From: Laura Gibbons [REDACTED]
Sent: 04 August 2020 16:46
To: Planning.Responses <Planning.Responses@arun.gov.uk>
Cc: Simon Davis <Simon.Davis@arun.gov.uk>
Subject: Y/59/20/DOC- Bonhams Field

Thank you for consulting us regarding conditions 12 and 14, we have the following comments.

Condition 12- surface water drainage design

CLIENT	Seaward Properties Limited				
PROJECT	Bonhams Field, Main Road, Yapton				
TITLE	Site Layout Proposed Drainage Plan				
DRAWN	M Pacifico		DATE	May 2019	
ENGINEER	S Magowan		CHECKED	SRM	
SCALE	1:500 @ A1 / :1000 @ A3				
			PROJECT NO.	23018	
			DWG No.	1210	REV. D

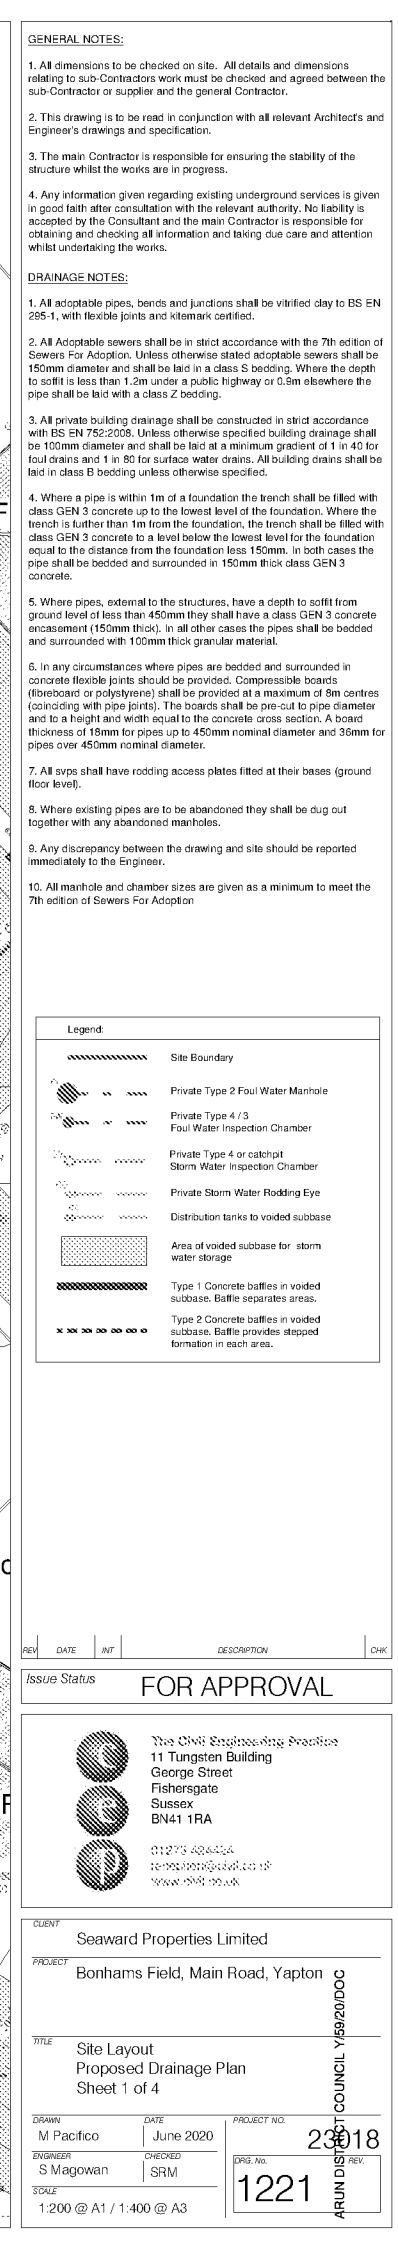
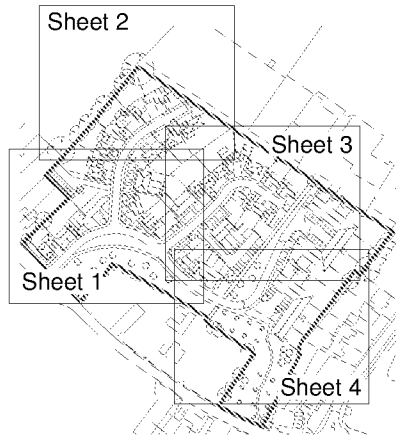
6. Once further site investigation is completed we will provide further comments. Based on a quick overview it is not evident whether the base of permeable paving is above peak groundwater levels, nor that all distribution tanks are at least a minimum of 5m from buildings.
